**A122 LOWER THAMES CROSSING (REF: TR010032)
DEADLINE 6 WRITTEN REPRESENTATIONS**

MELVILLE HAMILTON LOWE MOTT – AFFECTED PARTY REFERENCE: AP1308

C H L MOTT & M MOTT – AFFECTED PARTY REFERENCE: AP1369

On behalf of our above clients, the Mott family, we write further to Compulsory Acquisition Hearing 3 ('CAH3') held on 17 October 2023 with our written submissions in support of the oral representations made at that hearing.

Plate 25

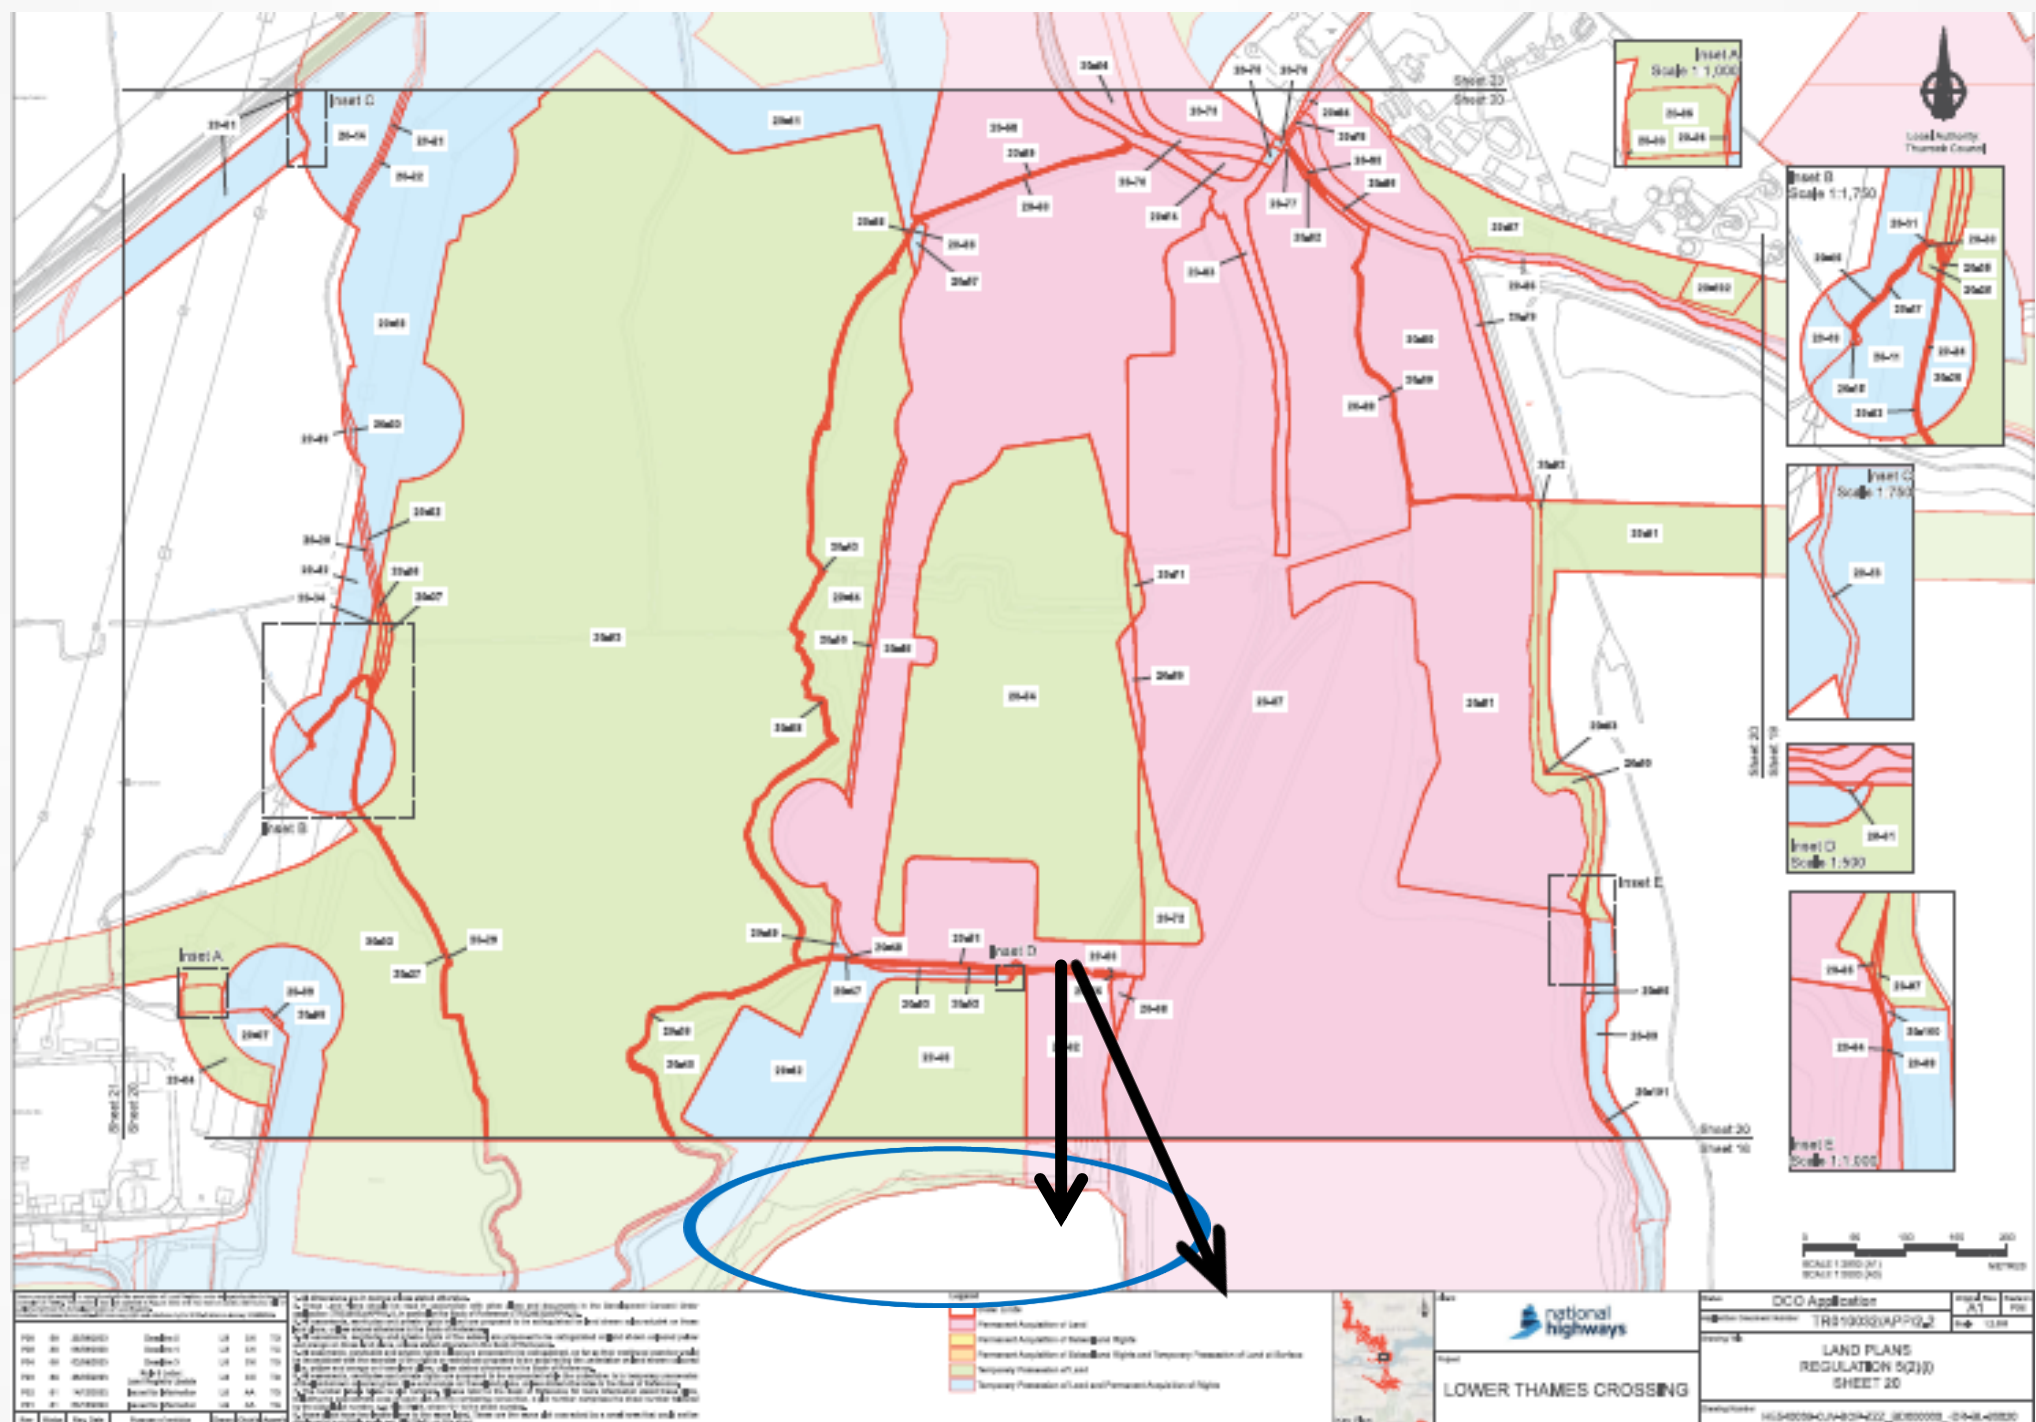
<p>Retained Land & River Thames Jetty/Wharf Access</p>	<p>Plate 25 shows the general location of the section 106 land and jetty/wharf complex associated with the current land restoration operations at Goshems Farm.</p> <p>Plates 26, 27 & 28 - show in broad terms, the routes that our client requires to be secured under the Project and through any land permanently acquired by the Applicant.</p> <p>The current jetty complex provides for a capacity of up to six barges in any 24 hour period; with each barge capacity equally approximately 1,500 tonnes of inert soil. This is the equivalent of removing approximately 300 bulk tipper lorries from the highway network in every 24 hour period and represents a significant benefit and asset for current land restoration operations and any future use of the river in this general area of Thurrock.</p> <p>With reference to 7.4 Project Design Report – Part D: General Design North of the River – Tilbury to the A13 Junction APP-511, on page 13 the Applicant states <i>‘Landfilling operations - These will continue after the Project is complete so access will need to be maintained and Project works designed for future loading.</i></p> <p><i>‘Landfills allow the Project to retain as much spoil onsite as reasonably practicable to limit number of vehicle movements. Integrate access, such as to existing jetties, into landscape restoration works’</i></p> <p>As the ExA will note, no such access route has been allowed for in the Tilbury Fields design for access to river frontage to allow for access to either the current wharf/jetties or any future location; principally through Plot 16-39 either from Station Road to the east of the LTC alignment or from extending the route of access from the proposed Northern Portal Access Track.</p> <p>We also draw the ExA’s attention to the fact that our clients land within Plots 16-40, 16-41 and 16-44 is not proposed to be permanently acquired by the Applicant and it is our client’s stated position that there may be reasons for relocation of the existing wharf/jetty complex to another river frontage location within our client’s ownership that this required route of access must also provide for in the future.</p> <p>Our submissions are as follows:</p> <ol style="list-style-type: none"> 1) The SACR v3.0 (SACR 006) provides for use of the Northern Portal Access Track for access to our client’s retained land during construction and permanent access post construction
